Please ask for: Mrs D Johnson
Email: daun.johnson@arun.gov.uk
Telephone: 01903 737762
Our Ref: WA/79/20/PL
Your Ref:
Date: 17th November 2020

Application for Planning Permission

Development: Demolition of existing dwelling & erections of 8 No. new dwellinghouses with associated landscaping & parking (resubmission following WA/30/20/PL). This application is a Departure from the Development Plan & is in CIL Zone 3 and is CIL Liable.

Location: Spindlewood Yapton Lane Walberton BN18 0AS

Second Floor Plan 1:100 @ A3

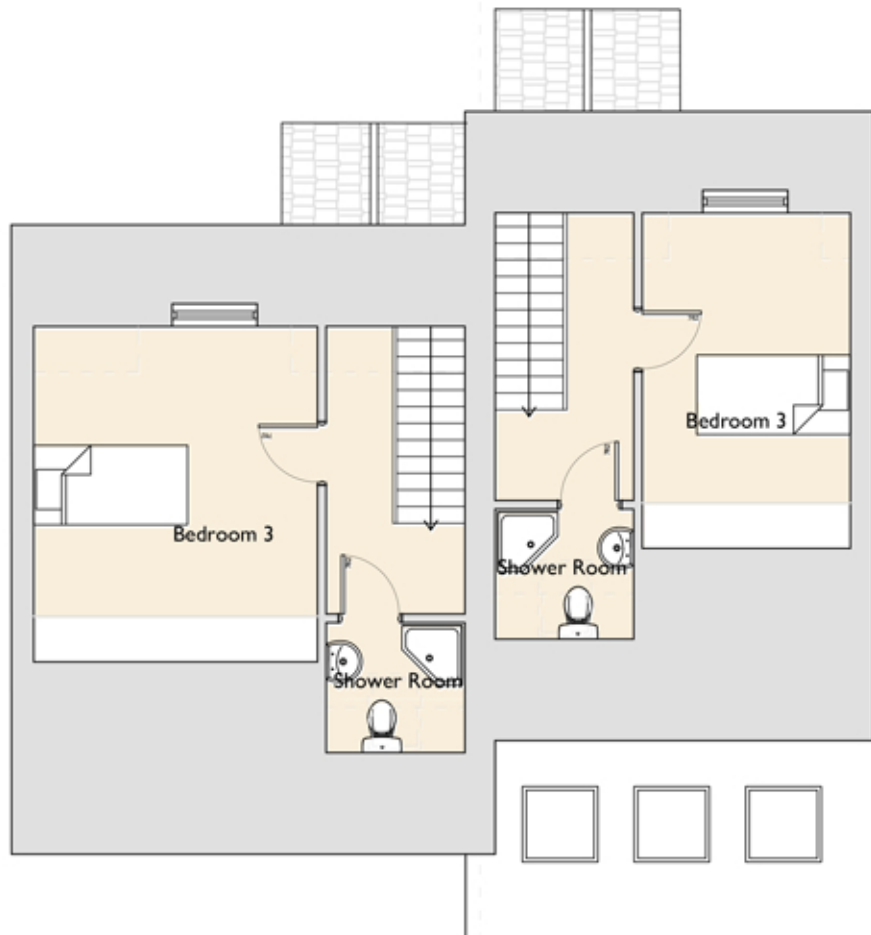
Please show the roof lights on the second floor plan for the cottages.
